From: Maria Tomalova
Sent: 20 August 2019 14:56
To: Planning Scanning
Subject: FW: BR/239/18/PL, 9 London Road

With regards to our recent telephone conversation I would advise you to withdraw the above application since it would be recommended for a refusal.

PROPOSED REAR ELEVATION

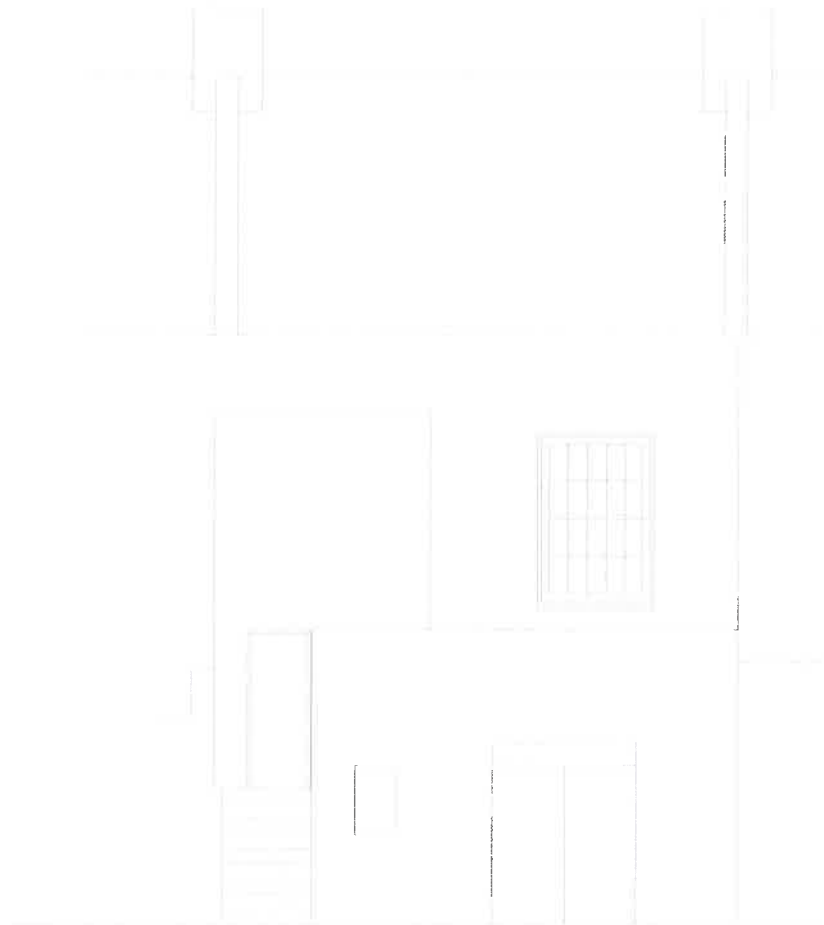
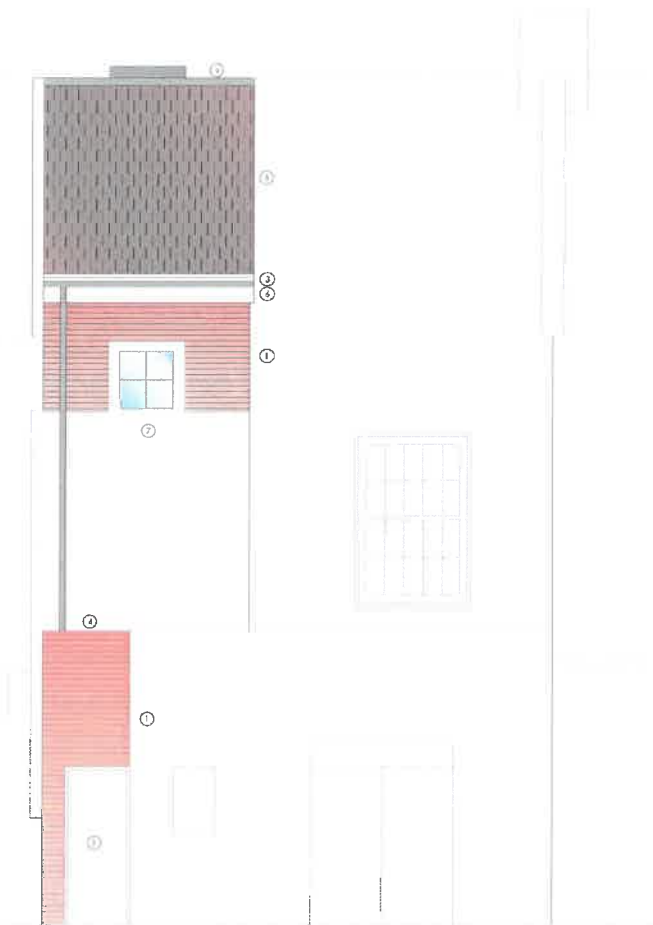
The change of use would be generally acceptable, however we can't support the proposed rear extensions.

The rear of your client's property is within a distance of 9m from the residential property opposite side with the only habitable room windows facing directly to the rear of the proposal site.

As a result all the proposed habitable room windows would overlook the front elevation of the residential property, violating their privacy and prospect.

To be acceptable as proposed, there should be within a distance of at least 18m between the rear elevations of these properties.
